Designing Out Crime Officer
Lancashire Constabulary
Saunders Lane
Hutton
Preston
PR4 5SB

19th April 2022

PROPOSAL: 36 x 2 Bed Bungalows
AT: Former Dexter Paints Site, Gannow Lane, Burnley

Internal Streetview looking west

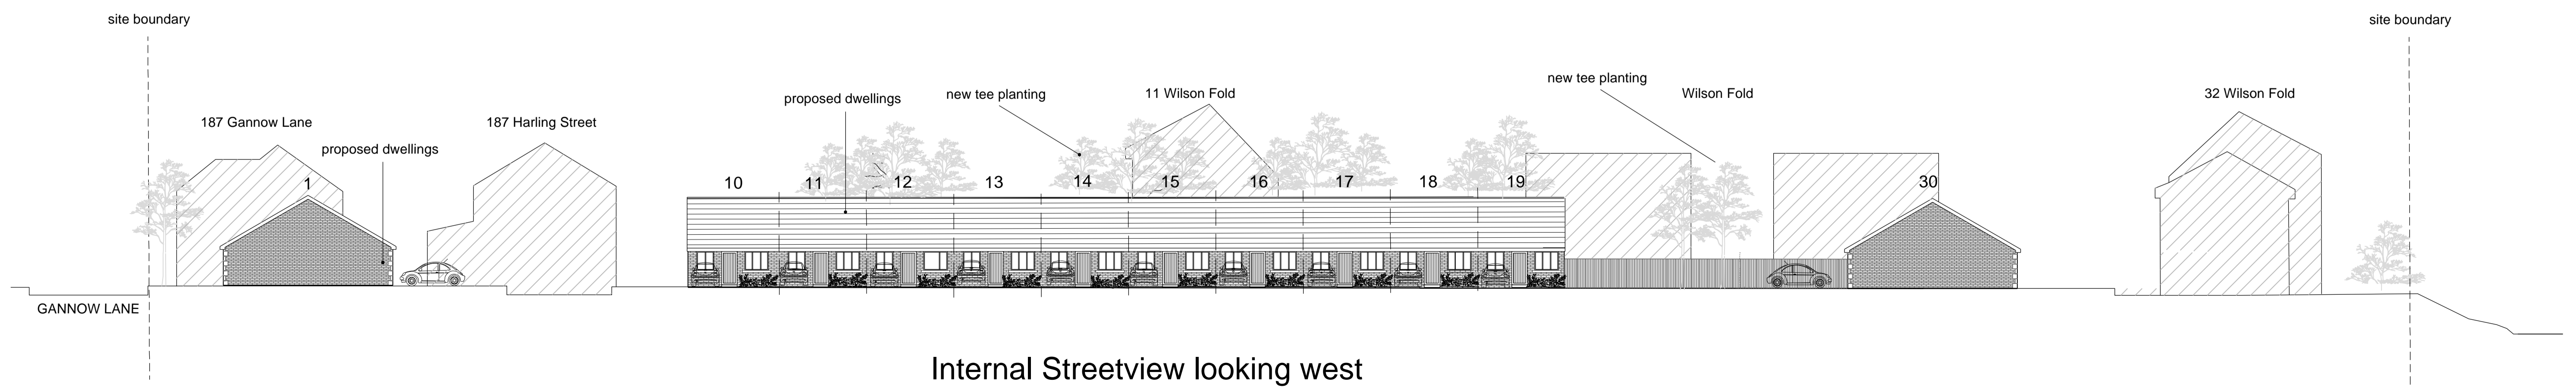
- o Boundary Treatments – It is important to clearly define public and private space. Boundary treatments should be a sufficient height and design to deter intruders. It is noted that the bungalows here are planned to have communal gardens only, without secure boundaries and it is possible to approach both front and vulnerable rear elevations of the buildings without passing through a gate or over a fence. This could leave properties here vulnerable to burglary and other crimes. A height of 1.8m close boarded fencing is recommended for the perimeter of rear gardens and dividing rear fences of the dwellings. Panels in the system should be secured so that they cannot be easily removed, and horizontal supporting rails should be on the private side so that they are not used as a climbing aid. Alternatively, each terraced block should have a secure communal garden separated from the rest of the development and surrounding areas, and accessible for those residents only.

- o Access Control – 1.8m high lockable gates should feature within fence lines of all rear gardens here to restrict access to the side and rear of the plots.

- o Driveways – Parking for vehicles on this proposed development is located near to the front building lines, overlooked by ‘active rooms’ in the property, this is recommended to maximise natural surveillance and reduce the opportunity for vehicle crime to be committed.
